PLANNING CONSULTATION RESPONSE

Application No	2026/0232
Proposal	Erection of 119 dwellings, open space and associated infrastructure
Address	Land to the south of Bloomhouse Lane, East of Woolley Colliery Road, Darton Barnsley
Date of Consultation Reply	21/05/26
Consultee	Highways DC

All comments refer to Drawing no. 25-5808-01-B.

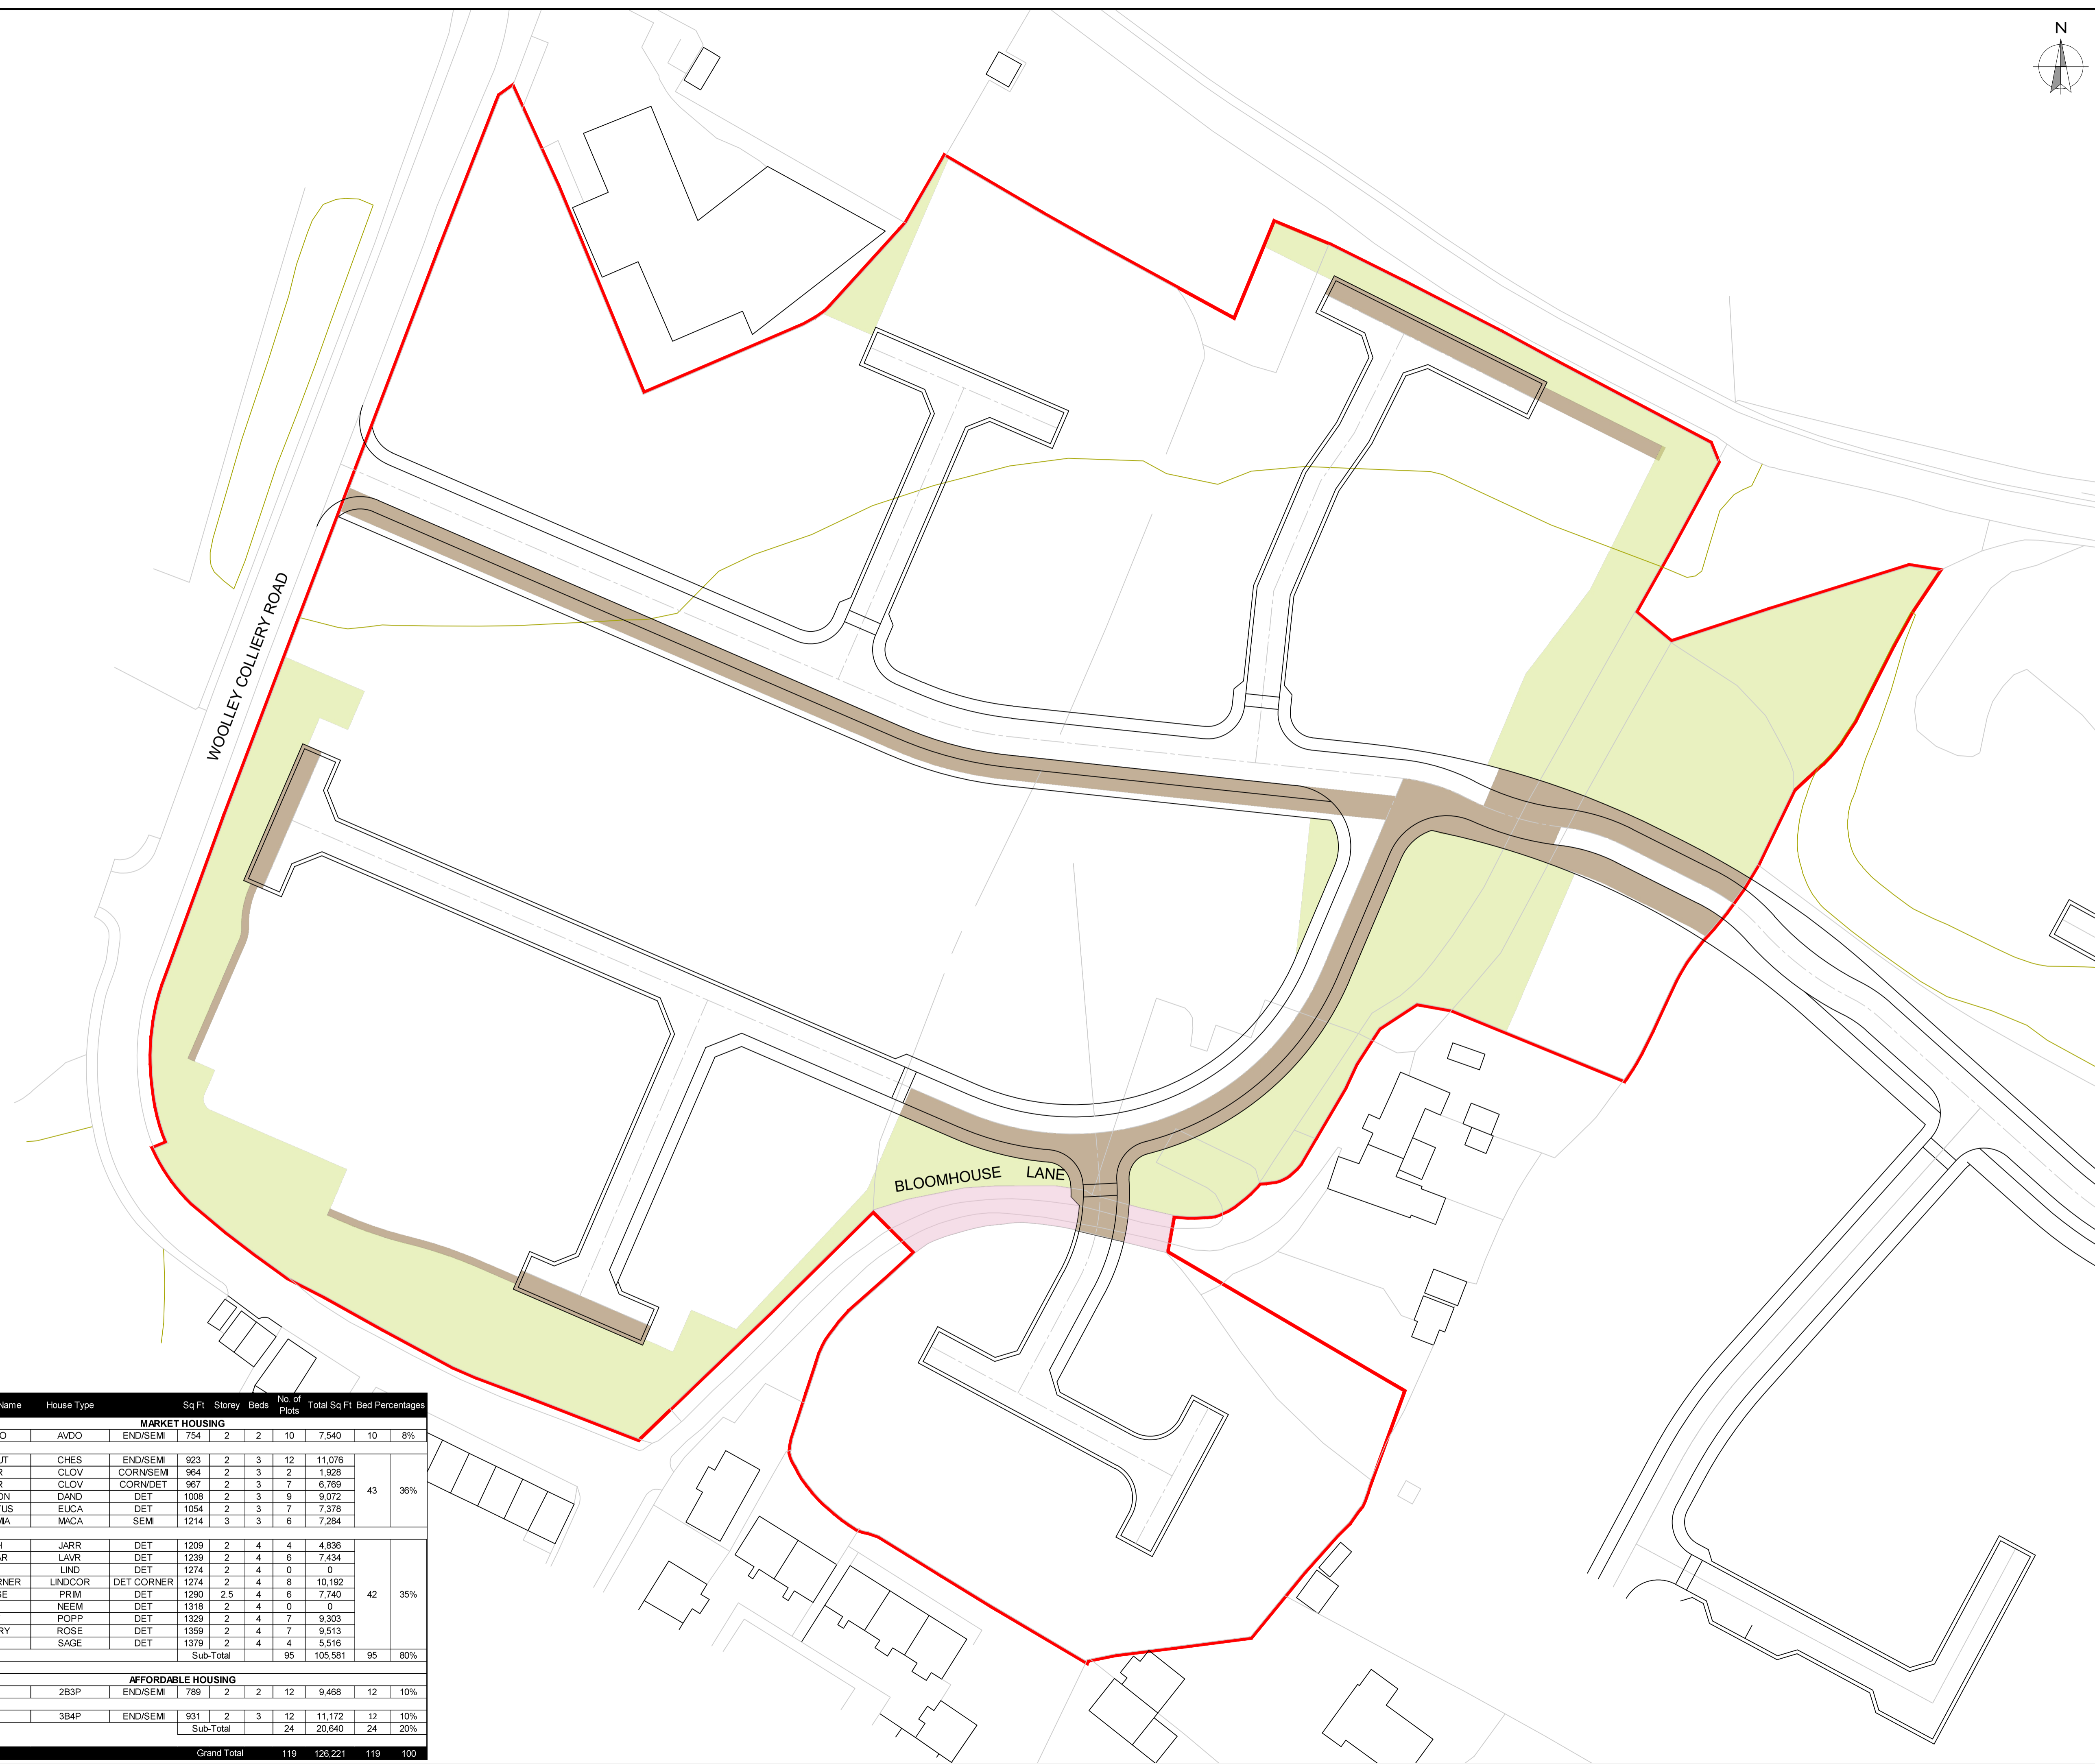
- It is imperative that improvements are made to the footway on Woolley Colliery Road to the south of the site. Discussions regarding the design have been ongoing between the Council's highway engineers and the applicants of the allocated housing site HS1 on the opposite side of Woolley Colliery Road to this application site (HS25) with gradients and vehicle swept paths still being addressed. Neither scheme can be granted permission without a detailed design being agreed and this may require land presently within the red line boundary of this proposal. As such, discussions are likely to be required between the two developers and the Council's Highway Design team to come to an agreed scheme that provides a satisfactory footway and drainage strip.

- Additional information will be required regarding the section of Bloomhouse Lane that is bridleway and accesses the existing dwellings. Presently, the only detail shows an arbitrary route over a new spur serving plots 111-115. A detailed design should be provided to show how users of the bridleway will safely cross the new section of highway. It is suggested bollards would be provided to restrict vehicular access, but these are not shown.

- Some of the visitor parking spaces are shown within rows of driveway apportioned to residential properties (examples include plots 12-14 and 55-58. Such spaces are unlikely to ever be retained for visitors, and if they somehow were, would only ever be the preserve of the fronting dwellings. Visitor parking should be provided at a rate of one space per four dwellings and be roughly apportioned to clusters of four dwellings per space. Some visitor spaces may be provided on-street, but where this is shown, localised widening should be provided as per the advice given in the South Yorkshire Residential Design Guide (SYRDG) Section 4B.2.1.9 which reads "where carriageway widths are less than 6 metres it will be necessary to discourage footway parking by providing defined parking bays beyond the carriageway or by some other means".

- Dead-end access routes longer than 20m require turning facilities for a fire appliance. This is stipulated in "Fire Safety: Approved Document B" of the Building Regulations. Whilst it is acknowledged that the present dead end by plots 117 and 118 is expected to be temporary, there is no knowing how long it will be until this becomes a through route to HS11 and beyond. As such, the road length from plot 45 would require a turning facility both for emergency vehicles and to conform to the maximum dragging distance for bins.

- Vertical deflection has been used to reduce vehicle speeds, but HDC would not want to see this form of traffic calming on a potential future bus route. The layout of the nearby Woolley

Grange housing development across the district boundary within Wakefield MDC shows an example of how the similar speed reduction could be achieved without using humps/tables.

- The ultimate intention for the site junction is to make the spine road the priority through-route and for drivers heading north on Woolley Colliery Road to give way. This scheme should not sterilise this preferred design and drawings should be provided to demonstrate this option is still workable and available in the future.

- As a shared-use path is only proposed on the southern side of the spine road, details should be provided to show the transition from the existing facility coming from the north on Woolley Colliery Road to the on-site path. This should be commensurate with the advice set out in government document LTN 1/20.

- The attenuation tank in the south-east corner will need to be a minimum of 5.0m away from the edge of the highway.
- Some Section 278 work will be required for a pedestrian crossing point on Woolley Colliery Road to connect to the allocated housing site across the road.

- Whilst the pedestrian connections onto Woolley Colliery Road are welcomed, some might not be feasible given the level differences. Consideration will also need to be given to the footway to the south of the site where a drainage channel is required and there is presently a 1:2 gradient retaining feature.

- Block paving shouldn't be used on the spine road, and engineers would prefer all raised tables (if any are retained given above advice) to be hard surface with only shared-use spaces being block paved.

- It is preferred that the crossing of the spine road along the bridleway is a standard dropped kerb rather than a raised table.
- The Council's Drainage engineers will provide full comments, but consideration should be given to the culvert that runs through the site which has previously caused a flooding issue to the south of the site.

- Any proposed ramps (such as the one adjacent to plot 72 and 73) should be designed to the below dimensions maintaining the advised gap between driveway and ramp:
